Ribble Valley Borough Council  
Council Offices  
Church Walk,  
Clitheroe  
Lancashire  
BB7 2RA

Phone: 0300 123 6780  
Email: [Kathryn.Walsh@lancashire.gov.uk](mailto:Kathryn.Walsh@lancashire.gov.uk)  
Your ref: 3/2024/0618  
Our ref: 3/2024/0618/HDC/KW  
Date: 18 December 2024

**Location:** Bolton Fold Farm Alston Lane Longridge PR3 3BN  
**Proposal:** Proposed change of use of a building and yard from agricultural to industrial storage and hardstanding. Replacement of existing walls and roof with new cladding and new roller shutter doors.  
**Grid Ref:** 360295 435306

The Local Highway Authority (LHA) are in receipt of an application for the proposed change of use of a building and yard from agricultural to industrial storage and hardstanding. Replacement of existing walls and roof with new cladding and new roller shutter doors.

Title
Vehicle Tracking from the Site Yard with Articulated Vehicle

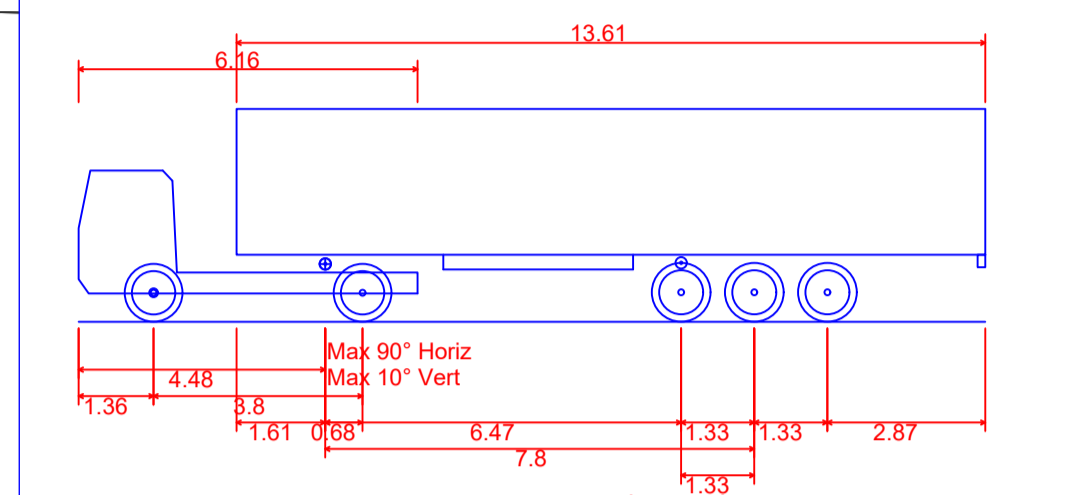
The applicant has provided further information regarding the vehicles which are expected to travel to and from site as well as detailed tracking and forward visibility as shown on the plan titled Vehicle Tracking from the Site Yard with Articulated Vehicle, drawing 590-24-4, and Vehicle Tracking into the Site with Articulated Vehicle drawing 590-24-3.

The LHA has reviewed drawing number 590-24-4 and note that 3 off street parking spaces will be provided within the development which will support the 3 members of staff. Turning provisions have also been shown on drawing 590-24-4 which are acceptable to the LHA and will not impact the parking area. Vehicle turning within will also allow vehicles to enter and leave in a forward gear.

The proposed giveway markings and signage are acceptable as shown on plan 590-24-4 and will reduce the chances of vehicles meeting along the internal access track. Reducing the need for vehicles to reduce into the access. The forward visibility will allow drivers to observe vehicles within the internal access track at the access.

2. The development hereby permitted shall not be occupied until such time as the parking and turning facilities have been implemented in accordance with drawing number 590-24-4. Thereafter the onsite parking provision shall be so maintained in perpetuity.

3. No part of the development hereby approved shall be occupied until all the off highway works (traffic signs for give way; road markings symbolising the give way internal road system) have been constructed and completed in accordance with drawing number 590-24-4.
